DECISION DELEGATED TO HEAD OF PLANNING

Application No: H09-0305-23 **Applicant:** University Academy Holbeach

Proposal: Construction of detached portal frame double height building & associated works - approved under H09-1181-22. Modification of Condition 2 to allow amendments to previously approved plans.

Location: University Academy Holbeach Park Road Holbeach

Proposed Elevations

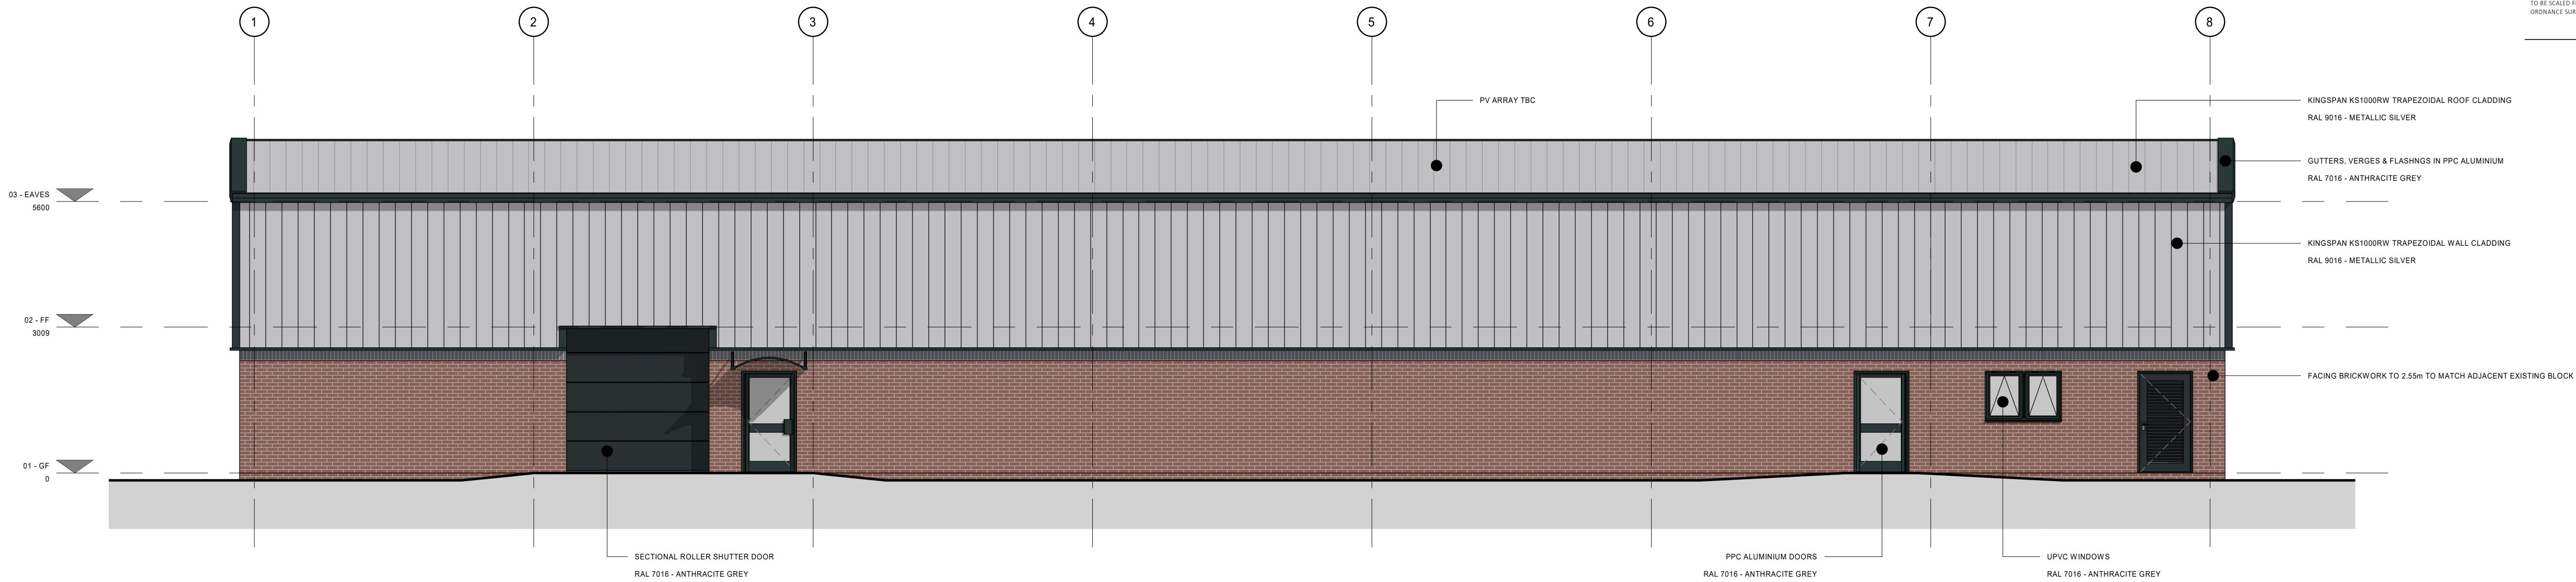
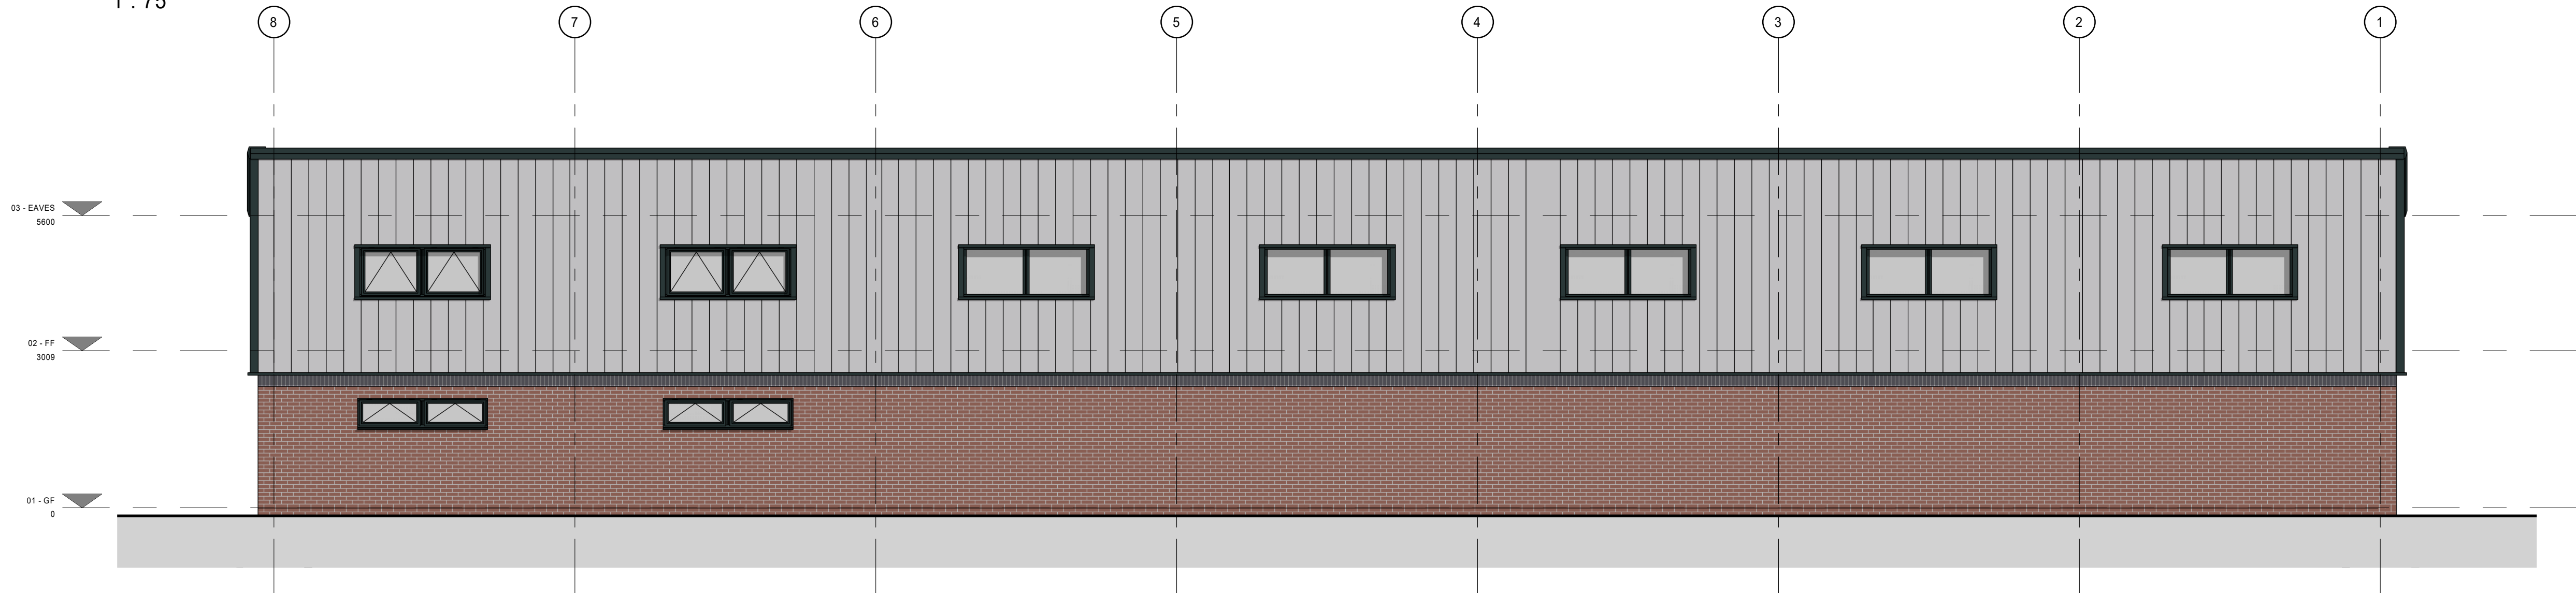
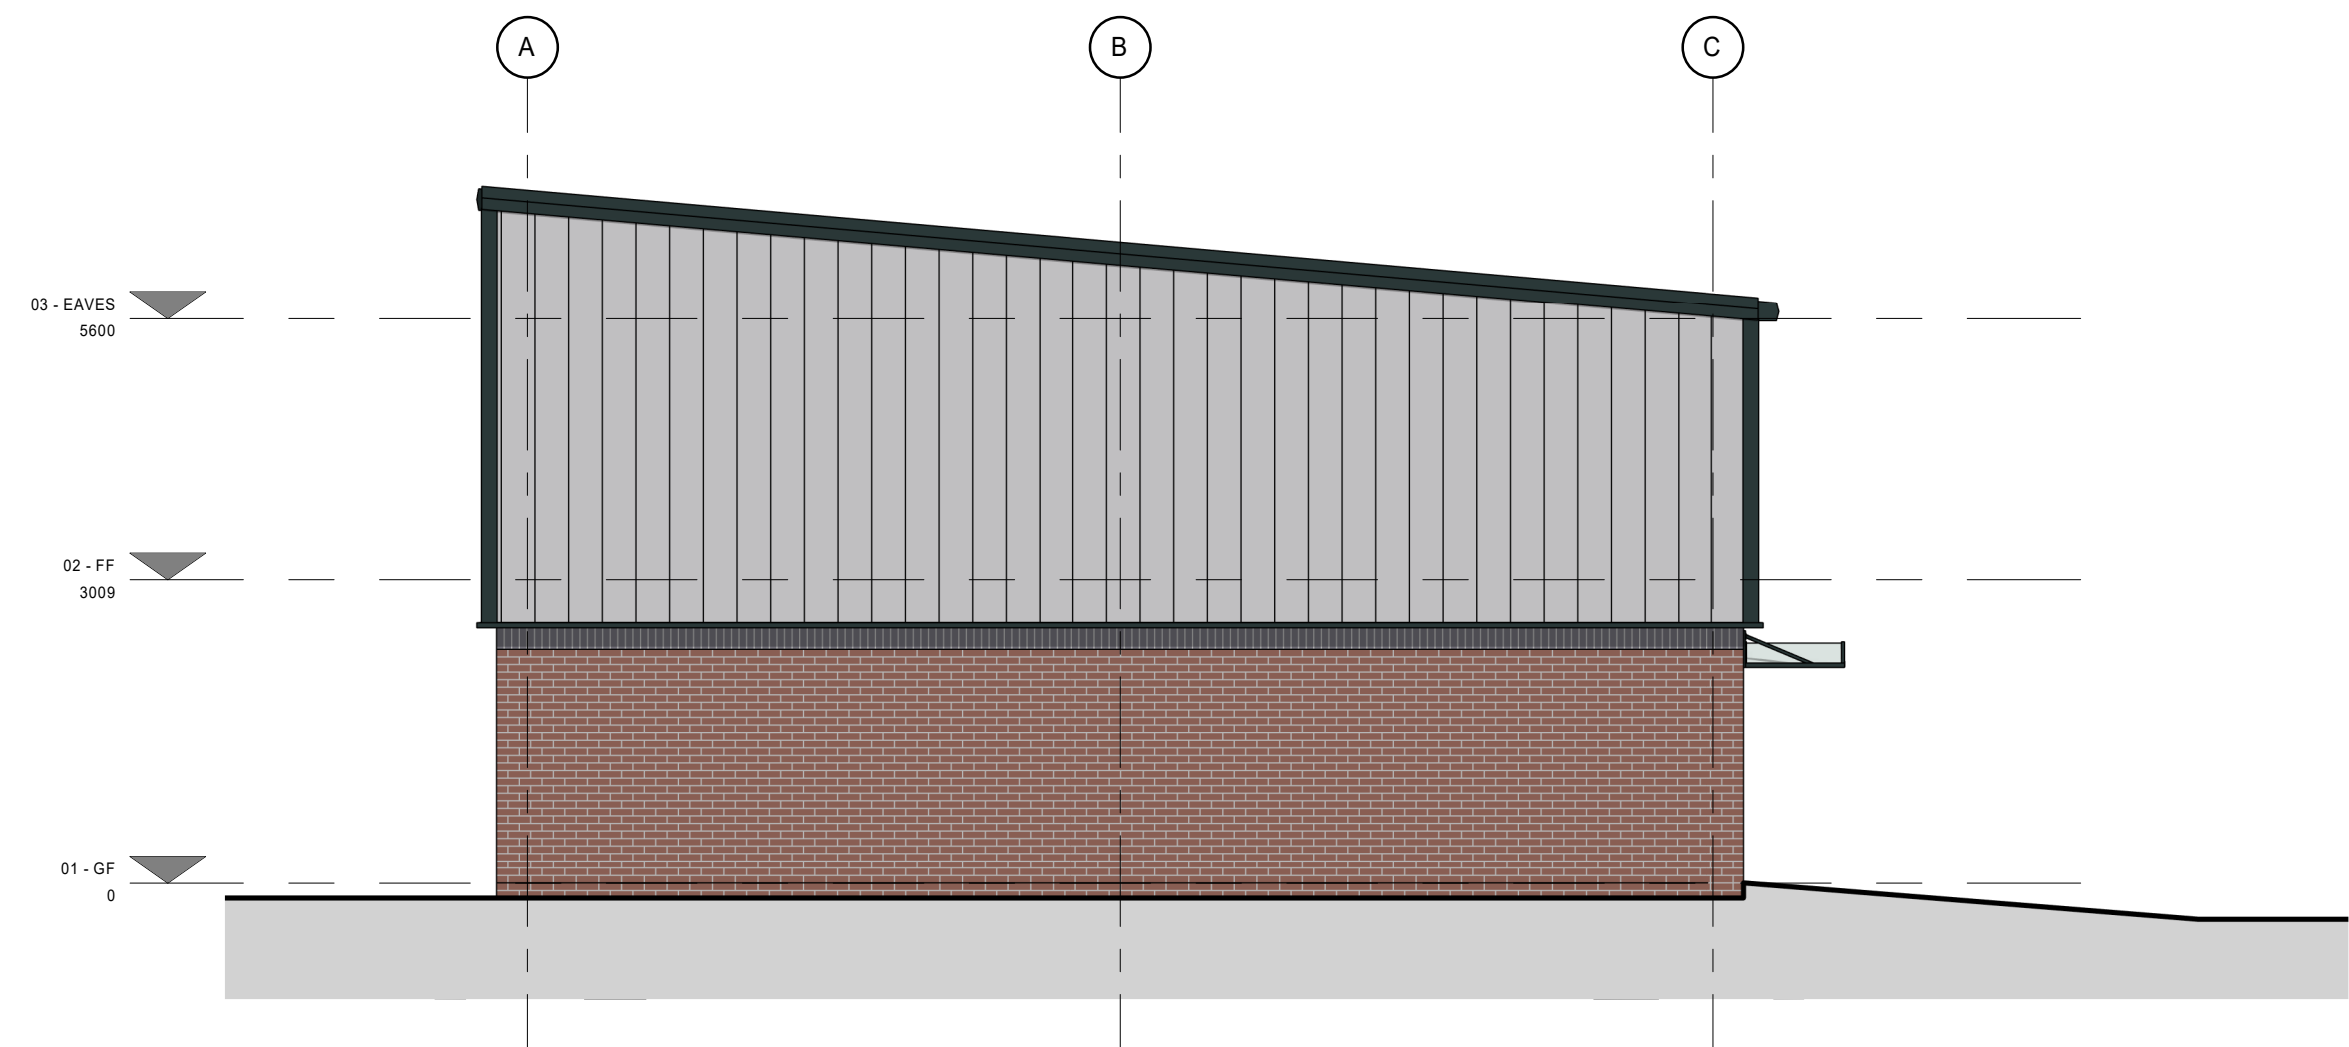
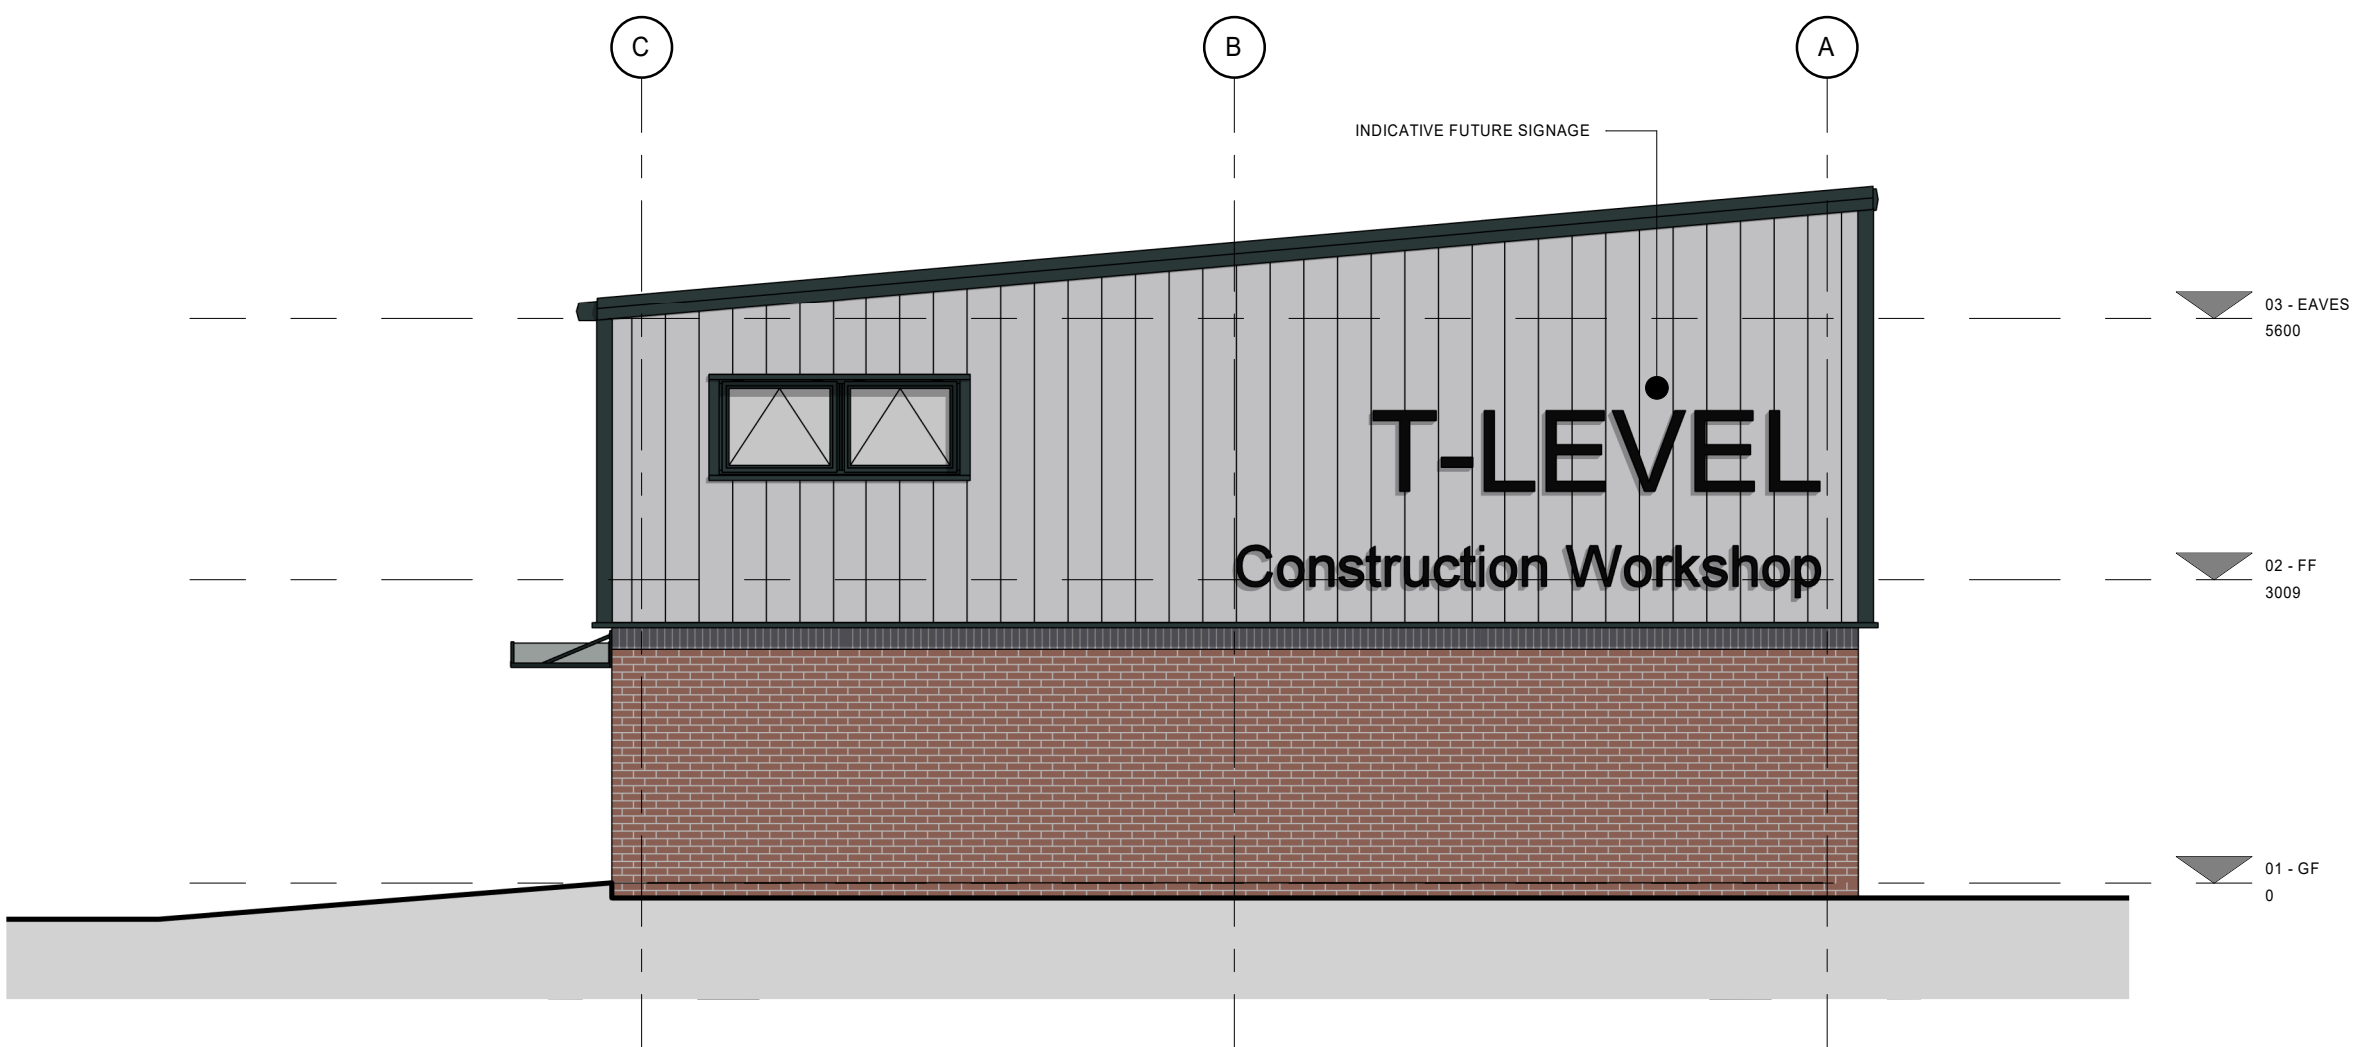
- 2no high level window openings in the northern elevation
- 1no new window opening and repositioning of 3no doors on the southern elevation
- Internal layout alterations
- Alterations to parking layout and reduction in parking spaces from 24 to 23

The proposed amendments are considered minor and would not significantly or unacceptably change the overall appearance of the previously approved scheme or result in any unacceptable impact to the character of the area.
